Application No: FP/228/21/T
Site Address: 11A Outerwyke Avenue Felpham PO22 8JH
Description of works: Reduce all limbs on 1 No. Turkey Oak by 2 m to leave 6m

Thank you for your internet representation made on 10th November 2021 which has been recorded as no objection with the comments as follows:

11A OUTERWYKE AVE

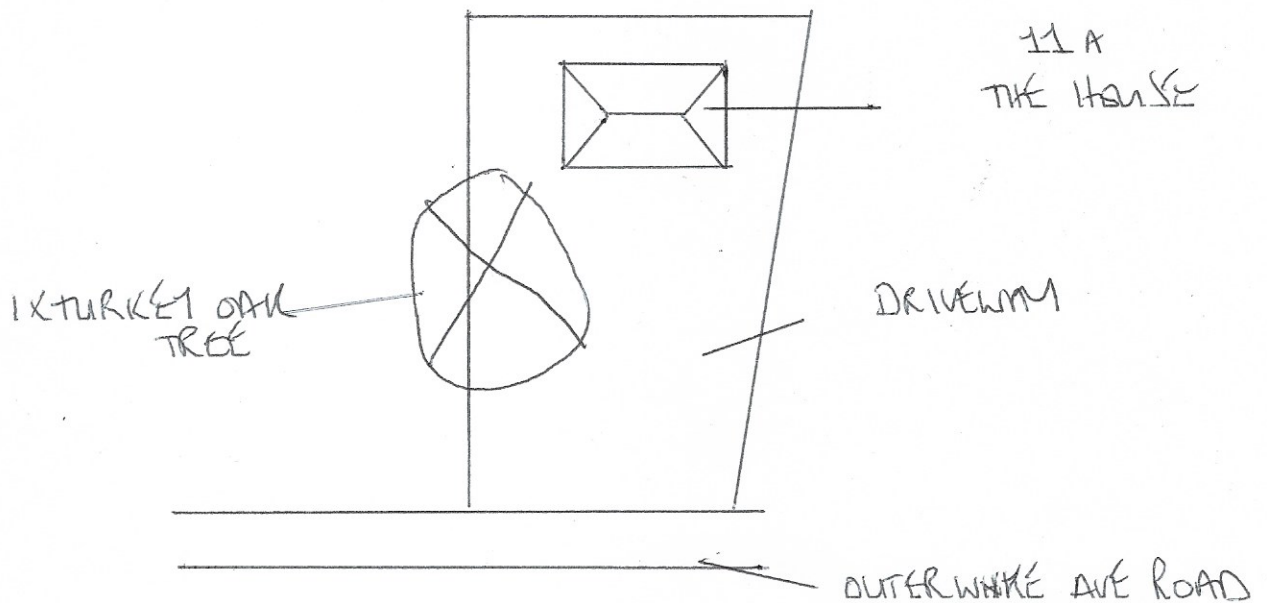
Felpham Parish Council has no objection to this application but our Tree Warden has identified the following: '11A Outerwyke Avenue: To keep turkey oak in a managed state, (based on its location and proximity to residential dwellings), the requested reduction of 2m to all limbs appears to be reasonable. However, on closer inspection there appears to be honey fungus fruiting bodies (destructive fungus which spreads underground killing roots) at the base of the tree and in a large cavity on the main trunk. I'd suggest the property owner obtains an arboricultural survey and resubmits an application based on the findings. Removal of tree is probable.'
